**KIRKLEES METROPOLITAN COUNCIL
INVESTMENT & REGENERATION SERVICE**

DELEGATED DECISION TO DETERMINE PLANNING APPLICATIONS

Reference No:	2023/62/90209/E
Site Address:	Land off, Thornhill Road, Dewsbury, WF12 9QE
Description:	Erection of detached dwelling and two storey workshops
Recommending Officer:	Nina Sayers

DECISION - REFUSE

Description
PROPOSED COMMERCIAL UNITS PLANS & ELEVATIONS

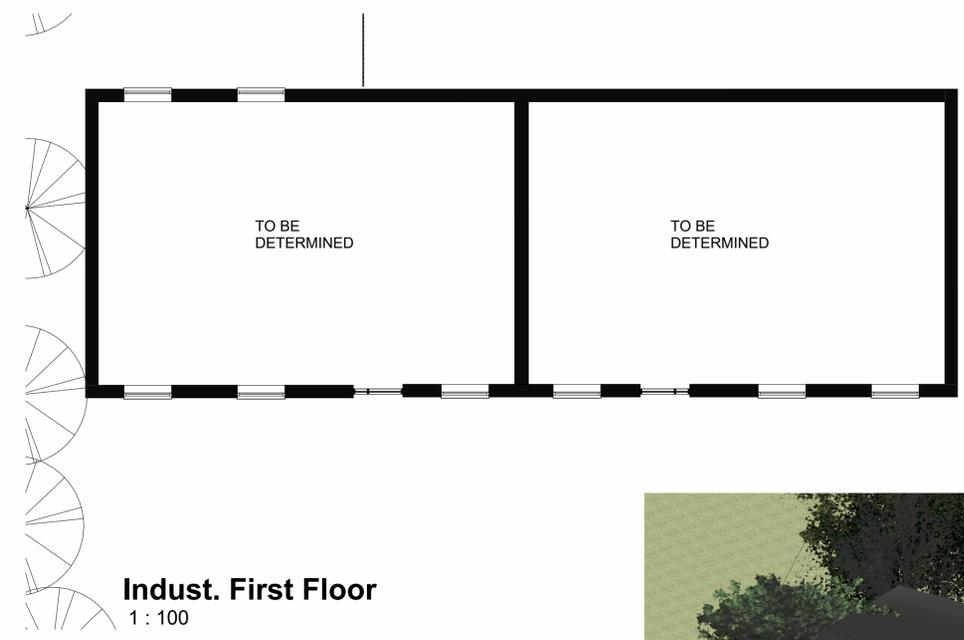
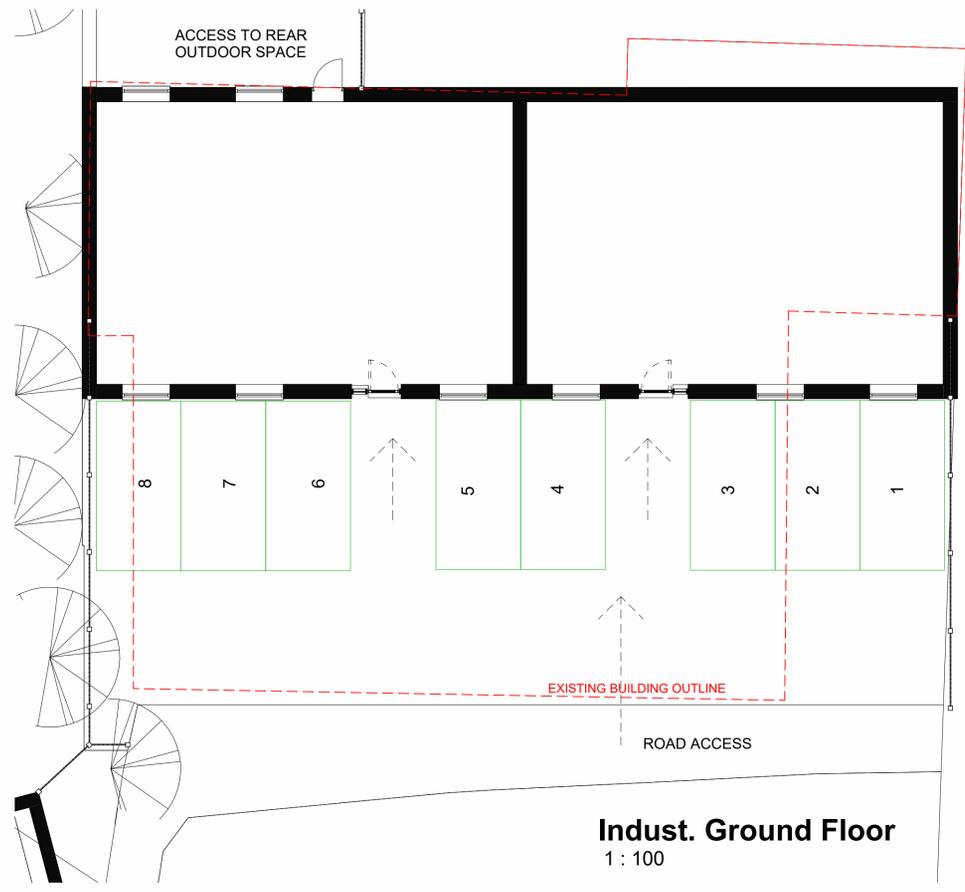
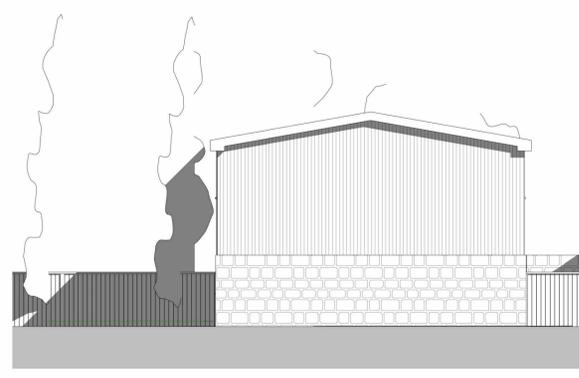
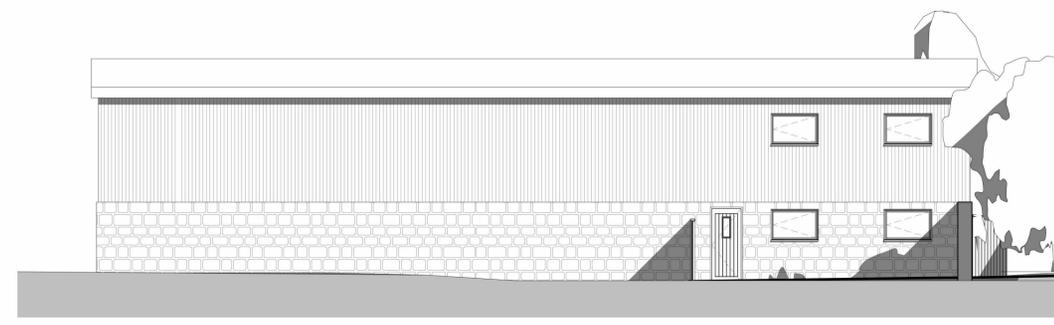
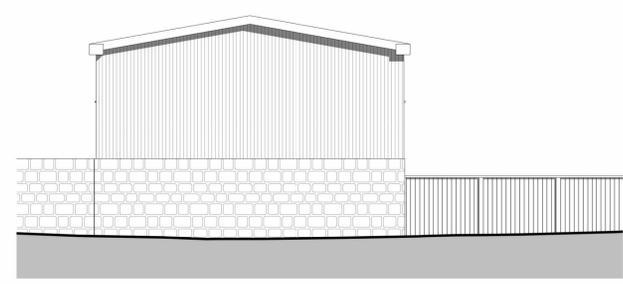
The proposed commercial unit would be a rectangular structure with a shallow pitched roof design. No details of materials have been submitted however this could be secured by condition should approval be recommended. The development would front Thornhill Road with parking to the front. Based on the information submitted, the proposal would be somewhat in keeping with the large commercial unit set to the east of the south, which is also visible from Thornhill Road. Therefore the proposed commercial units are considered to not cause any significant harm to visual amenity.

The new industrial units would have a roadside frontage with forecourt and parking area. Whilst there would only be two units, each would have a larger footprint than the existing units and would be two storeys to allow office/storage space on the first floor.

KC Highways DM (HDM) were consulted on the proposal and raised concerns regarding the proposed parking provision. The existing workshops have insufficient off-street parking and cars visiting the business, or being repaired, park in the area to the front of the units and spill out onto the highway which

creates highway safety issues, HDM would not want to see this situation repeated with the new development. The submitted Site Plan is unclear as far as access and parking for the proposed detached dwelling is concerned. The Council request a new 4-bedroom dwelling to provide at least three off-street parking space. A single integral garage is proposed in the dwelling which would provide parking provision for one vehicle and it would appear that given the space to the front of the property, there would be sufficient space for parking two vehicles. Therefore, whilst this has not been demonstrated on a site plan, as requested, it is considered this would not warrant a reason for refusal in this instance.
